Development Control
Ribble Valley Borough Council

App no: 23.0004

Address: Pavement outside CJ's 75-77 King Street, Whalley

Proposal: Proposed installation of two digital 75 inch LCD display screens, one on each side of the Street Hub unit and associated display of advertisement to both sides of the unit.

DRAWING TITLE
**BT STREETHUB
CLT-205**

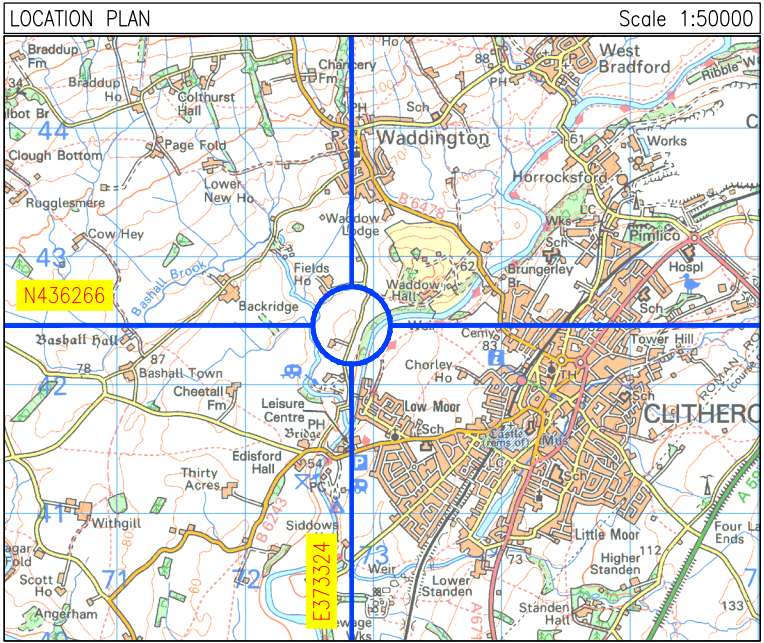
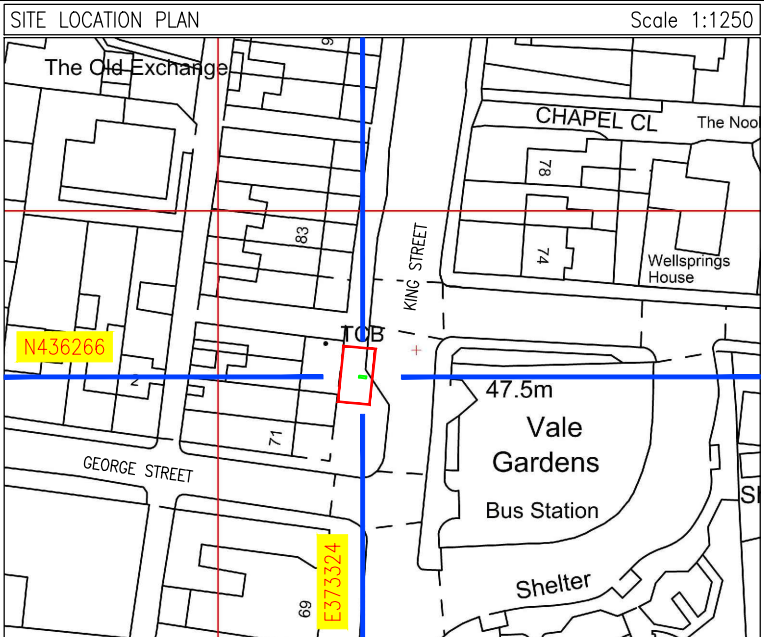
The proposed sign position raises highway safety concerns. The sign location is in close proximity to a zebra crossing, a bus stop layby and two side road junctions named George Street and Woodlands Drive. There is a collision recorded on King Street at the junction of Woodlands Drive between a vehicle and cyclist resulting in a slight injury to a cyclist. There is a high level of conflict between vehicles, pedestrians, cyclists and horse riders at this location.

There is a private vehicle access on King Street between 77-79 King Street. The proposed sign location obstructs the visibility splay for drivers emerging onto King Street at the access. For this reason, we would raise an objection to the proposal.
